Your reference: 3/2025/0467

Regarding Planning Application 3/2025/0467

Having initially reviewed the above application, as supplied and published by Ribble Valley Borough Council Planning Department, to permit a full and detailed analysis we have observed that the Proposed Elevation Drawings 10MS-PL02 do not yet detail two critical features:

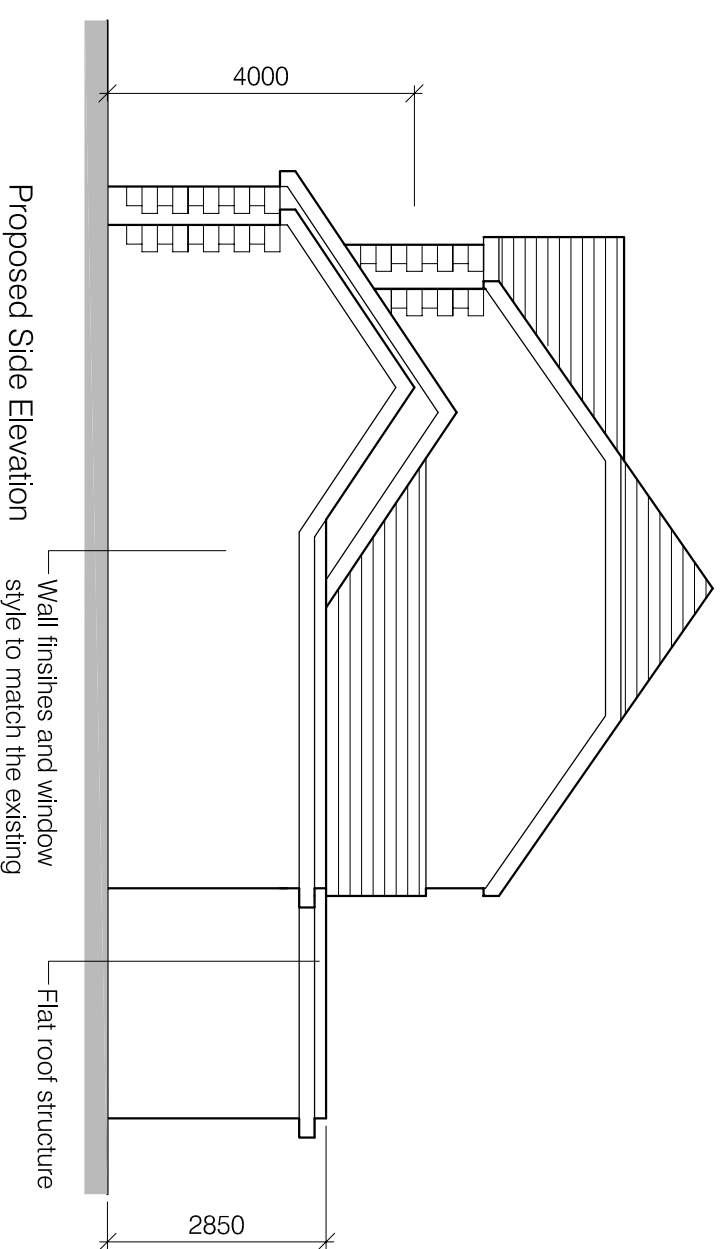
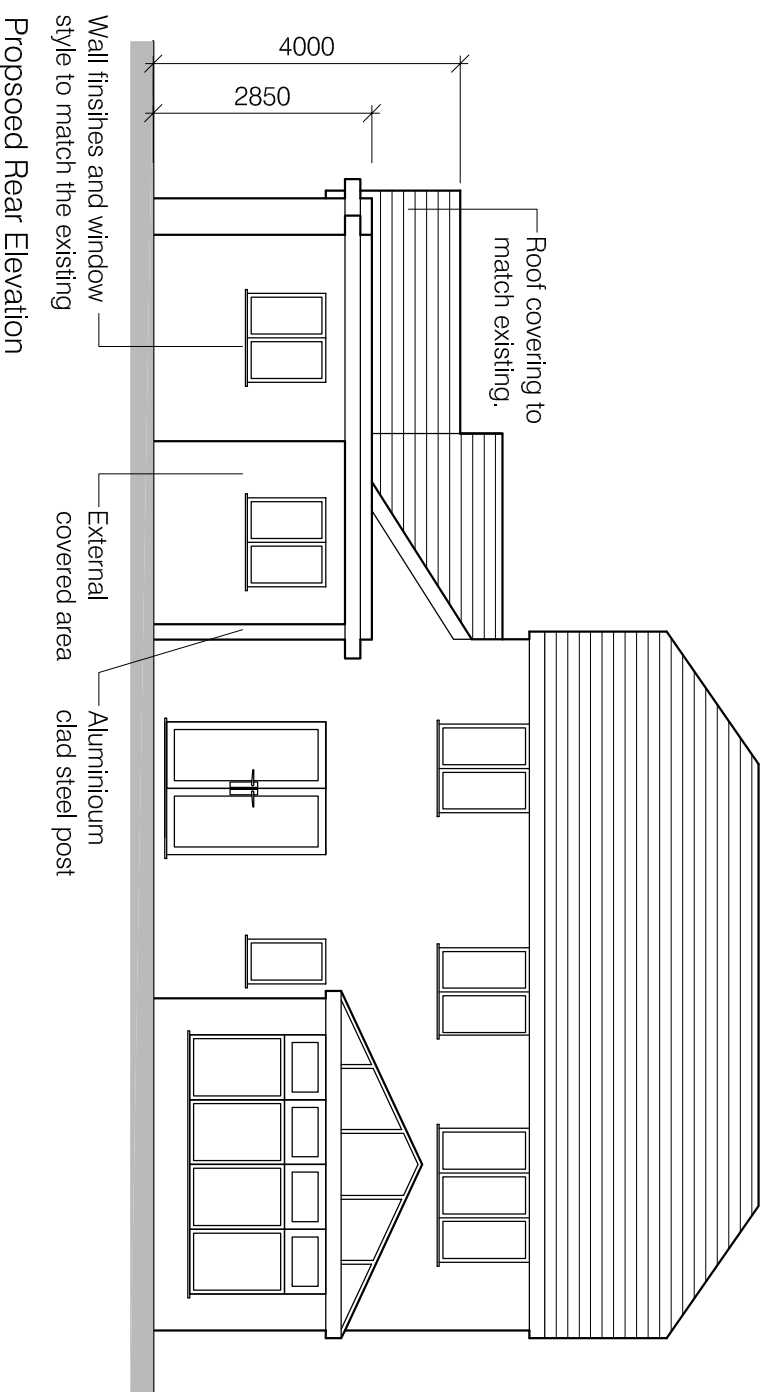
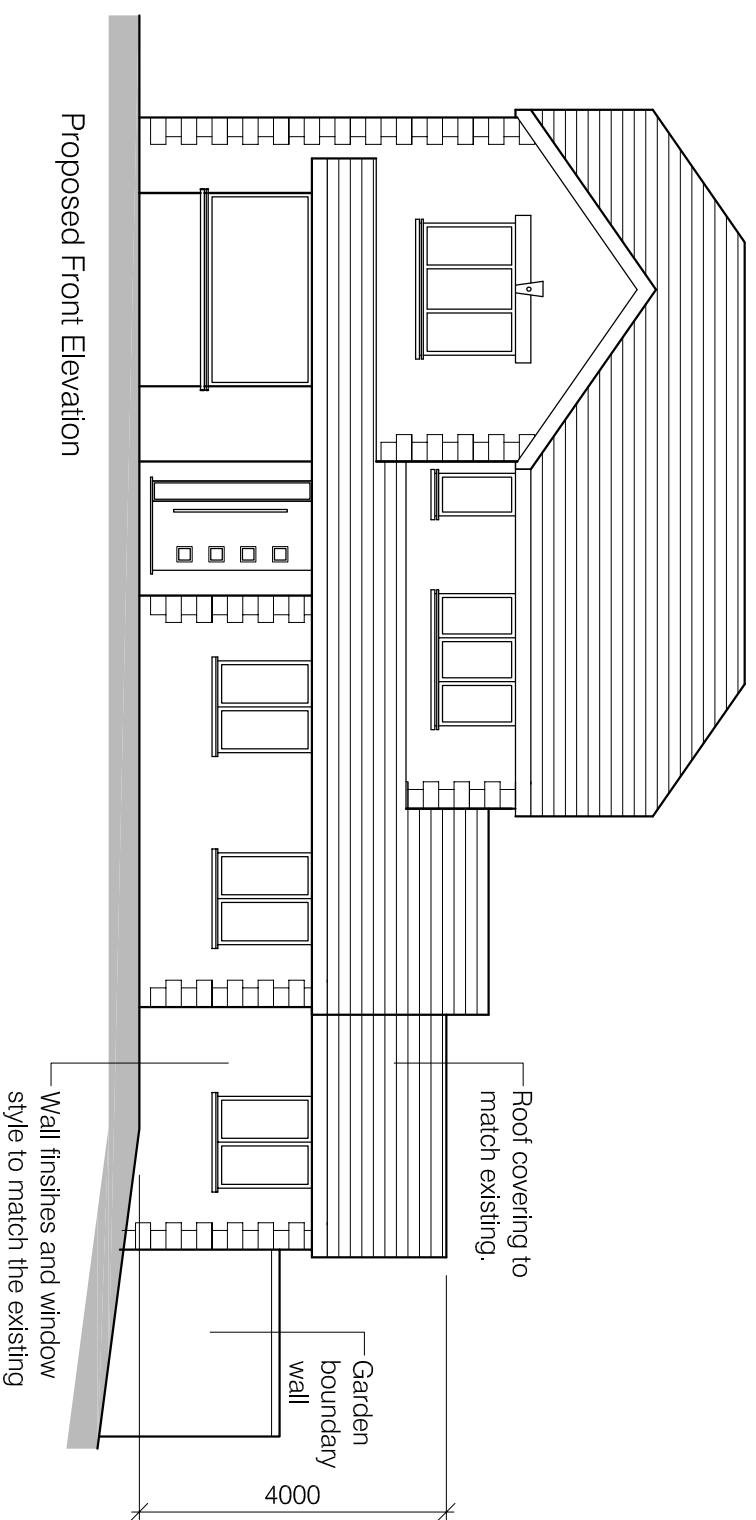
1. 
 This is significant in the effective consideration of any potential direct impact to the integrity, and future maintenance,

2. The planning application does not yet consider, or identify, any direct impact the proposed extension may have with regard to construction 
the development and for any
